**From:** Sue Howell <Sue.Howell@arun.gov.uk>  
**Sent:** 22 January 2025 17:28  
**To:** Planning.Responses <Planning.Responses@arun.gov.uk>  
**Cc:** Simon Davis <Simon.Davis@arun.gov.uk>  
**Subject:** Planning Consultation on: P/114/24/RES

### **Response to Planning Application**

**Description:** Reserved matters application (pursuant to outline permission P/178/21/OUT (APP/C3810/W/22/3302023)) for matters of appearance, landscaping, layout and scale concerning the construction of 95 new homes along with new pedestrian and cycle links, open space, landscaping, habitat creation, drainage features and associated groundworks and infrastructure. This development is in CIL zone 5 (CIL liable as new dwellings) and may affect the setting of listed buildings

**Location:** Land West of Pagham Road Pagham

Project Land West of Paghram Road
Drawing Boundary Material Layout

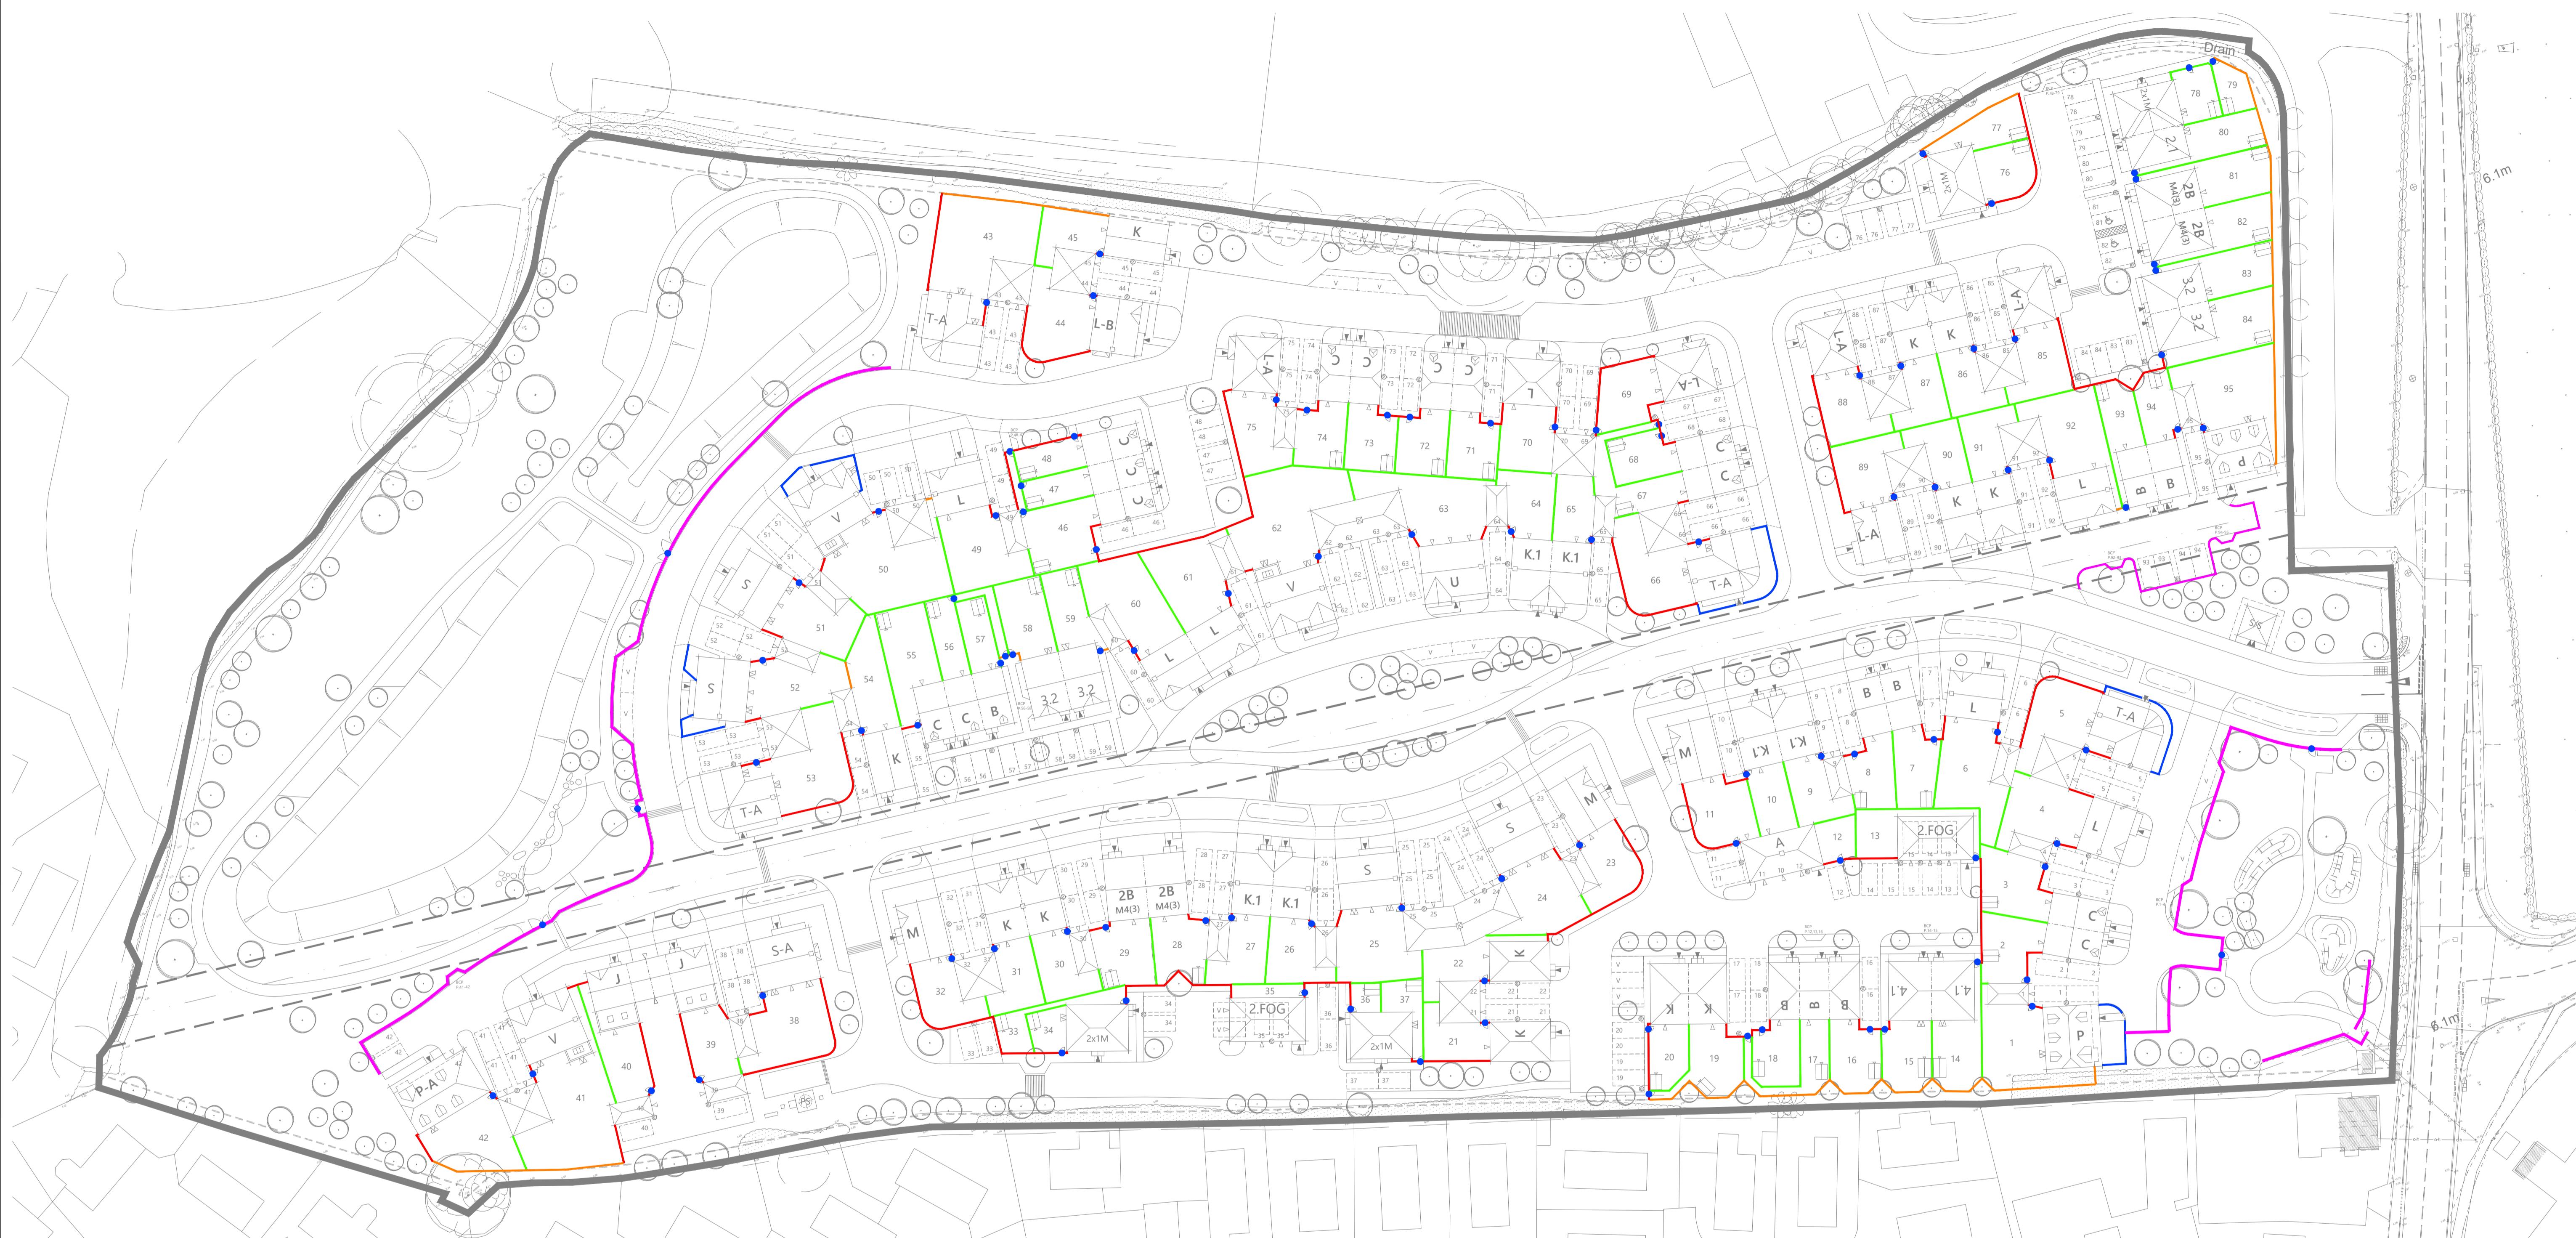
Fencing to the play area has been shown as cleft chestnut post and rail fencing, with 3 horizontal bars at 1200mm height with self-closing timber pedestrian gates, which is not the norm for a play area but not unsupported.
